## KITTITAS COUNTY COMMUNITY DEVELOPMENT SERVICES

### **RE: CU-24-00001 Vantage Valley Properties - Transmittal of Comments and Request for Additional Information**

CROSS VALLEY
 NATIONAL TRAINING
 CENTER
 SITE PLAN
 OCTOBER 9, 2023

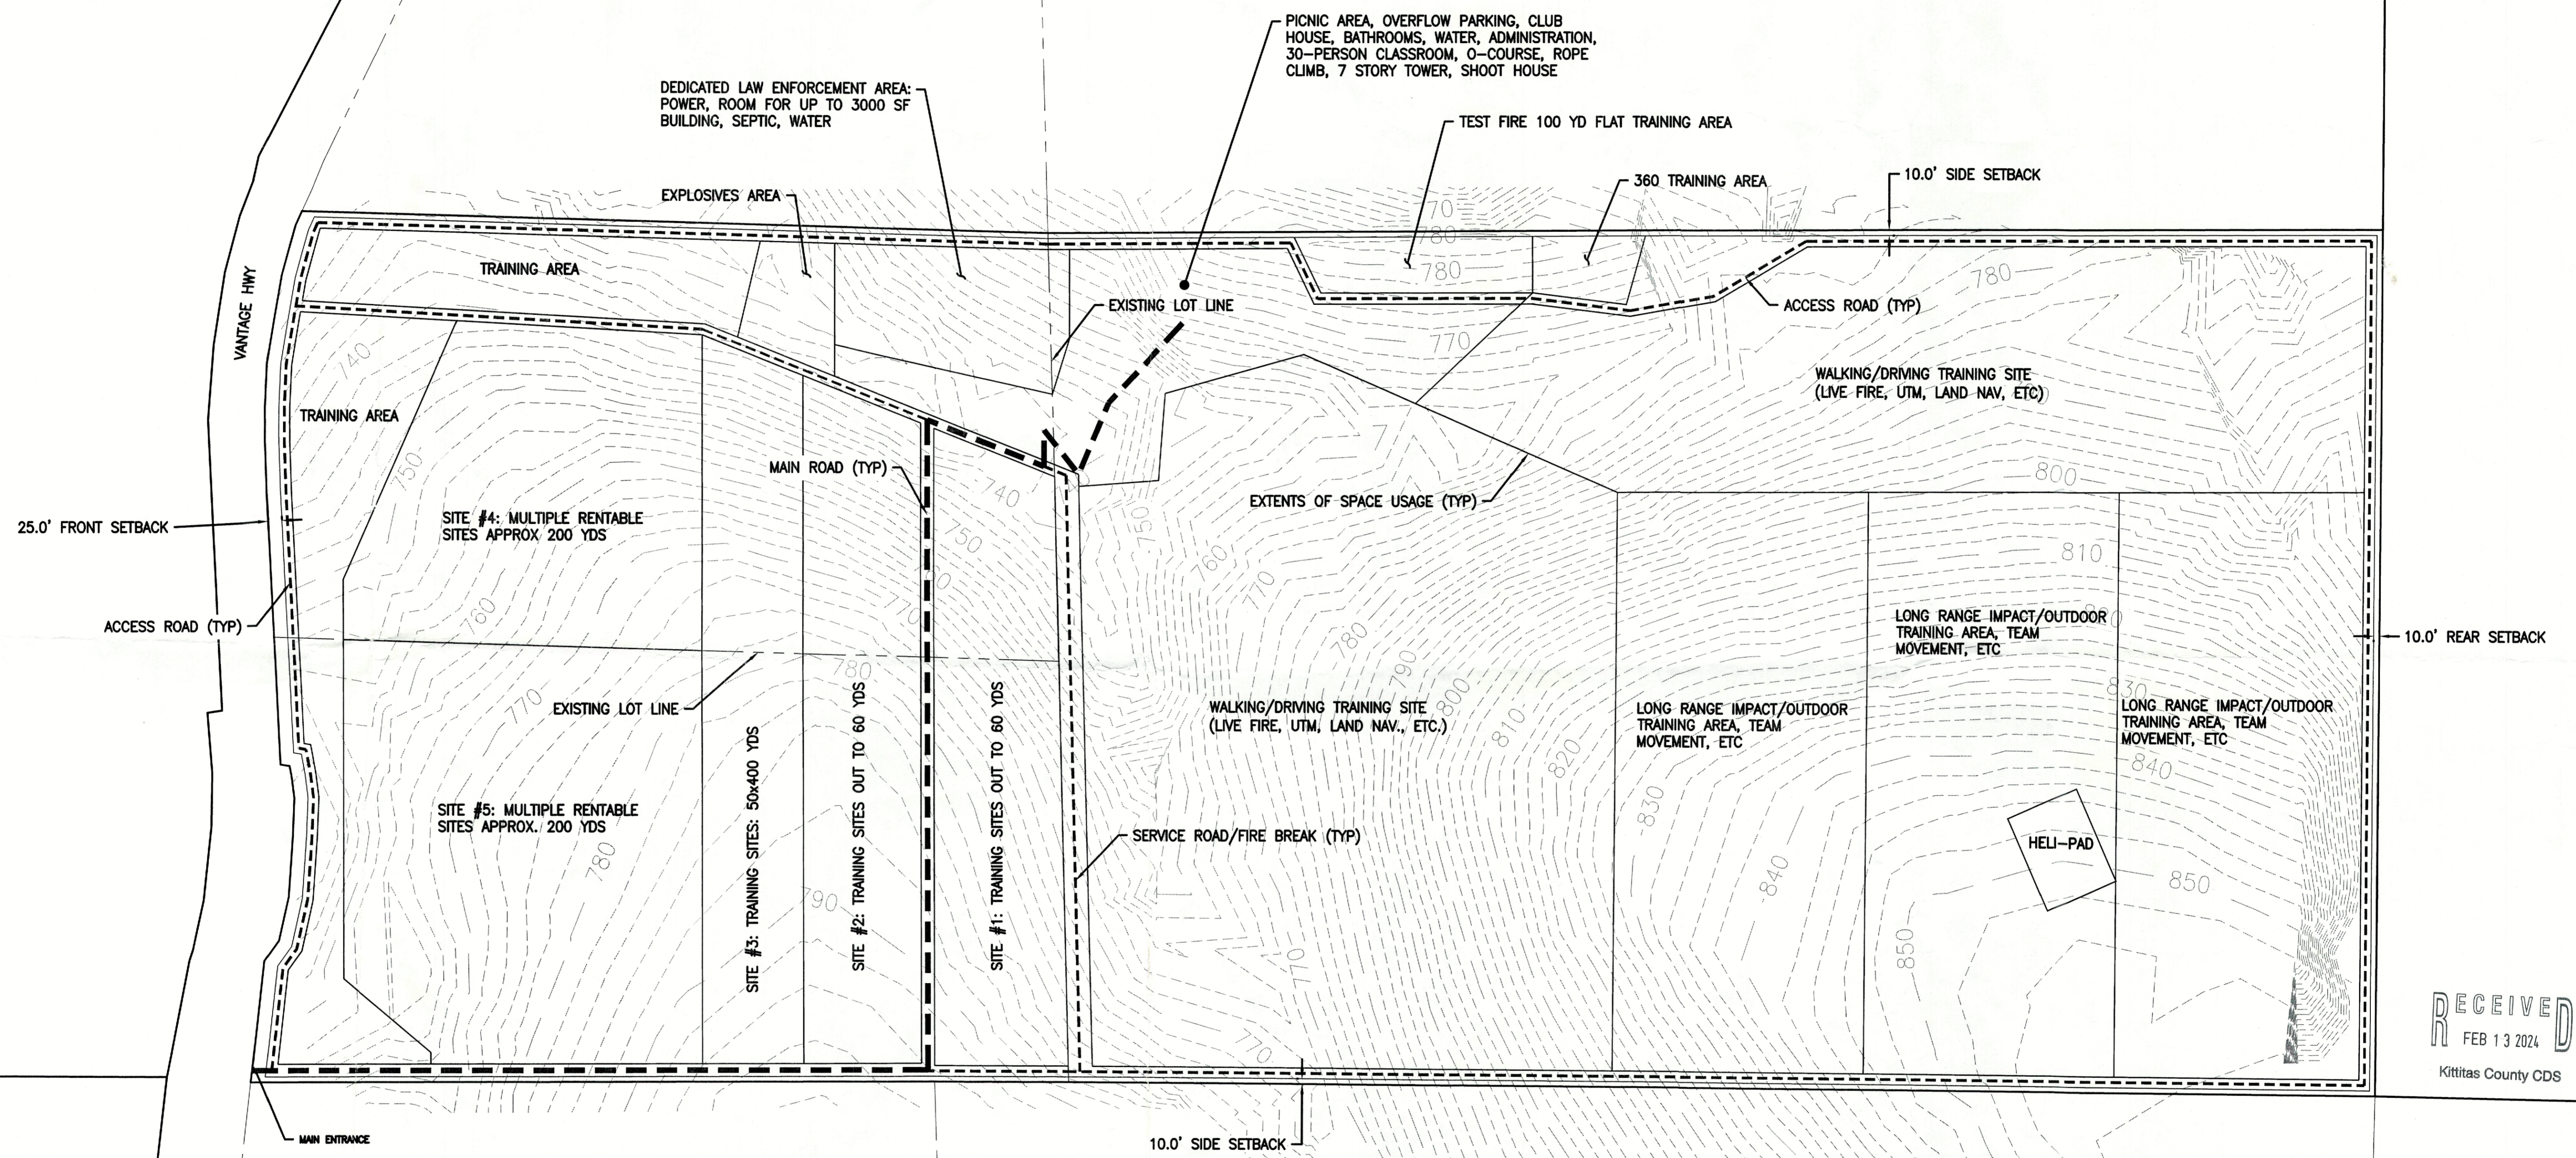
- Updated site plan to show the following:
  - Updated Main Access
    - Per the comments received from Kittitas County Public Works, the proposed main access is not permissible. Please contact Public Works for access requirements.
  - Kittitas PUD easement
